Case Officer: Imogen Hopkin

Recommendation: Refuse

Proposal: Discharge of Condition 5 (Site Development Scheme) of 20/02060/F
(Appeal ref APP/C3105/C/21/3268454)

DRAWING No. PBA 4

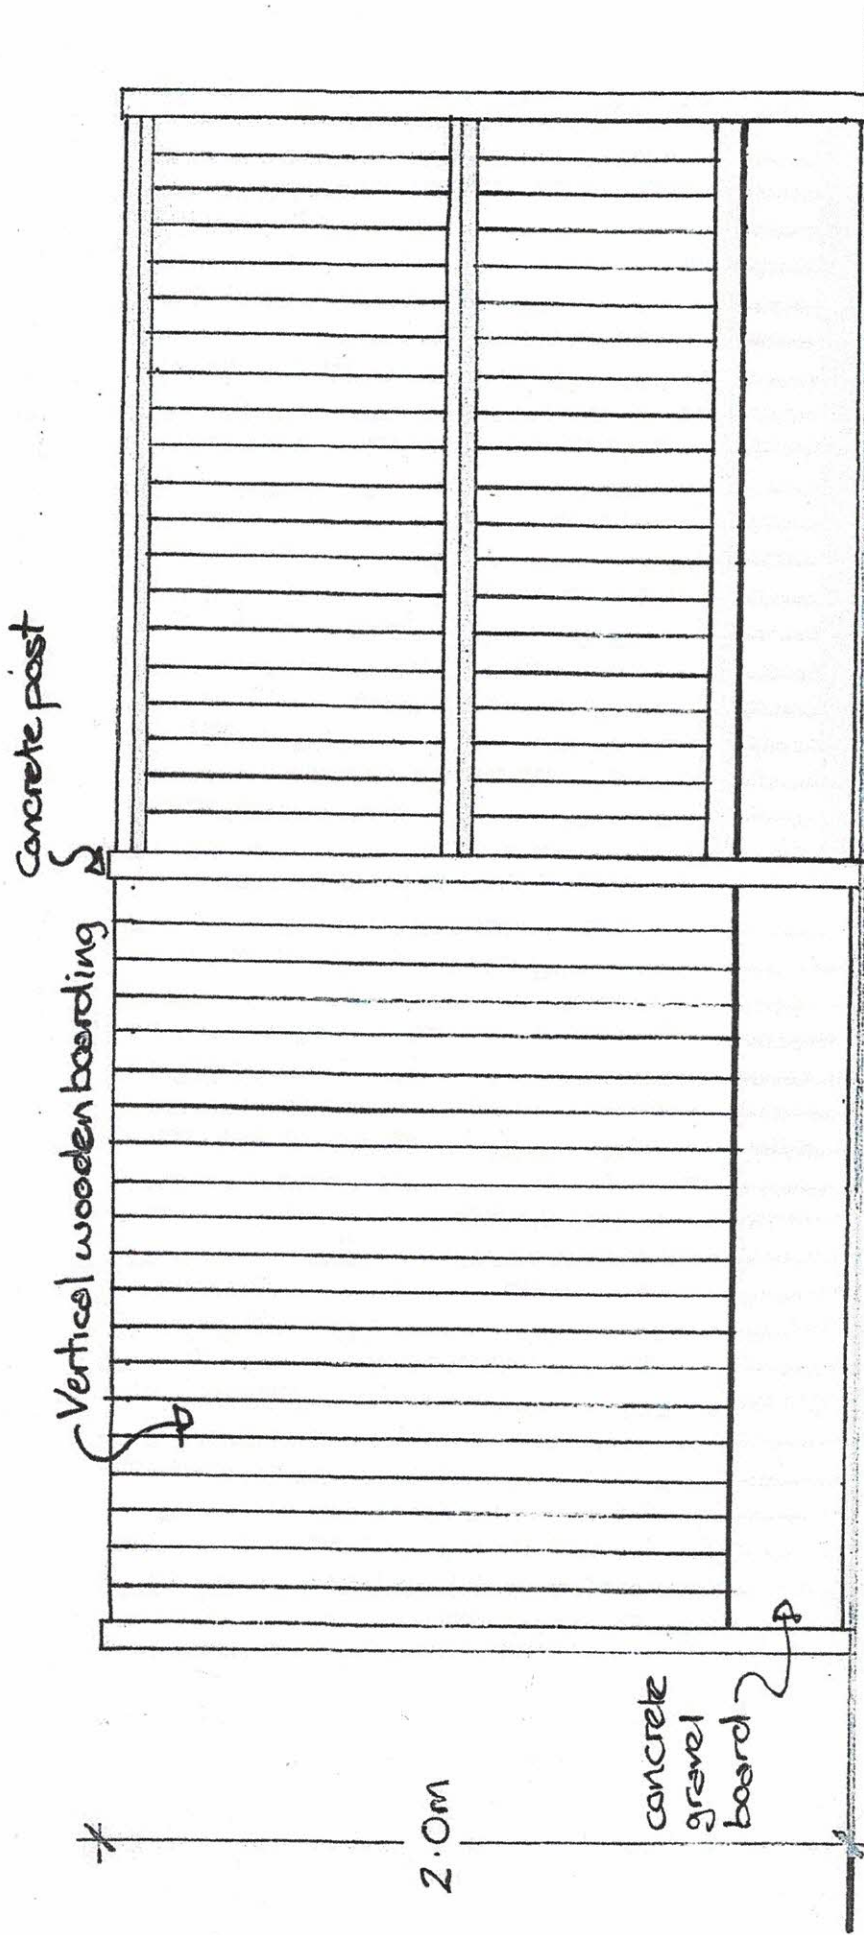
- 6.6. The information provided includes a front and rear elevation of fencing, and a post and rail fence. The drawings provided to demonstrate these are not detailed, and there is no indicative material shown. There is no indication of the siting of either of these boundary treatments, and the condition requires the boundary of the site and between pitches to be provided. The applicant has not complied with this element of the condition, as there is insufficient information to assess the position of the boundary treatments, and to fully understand the design.
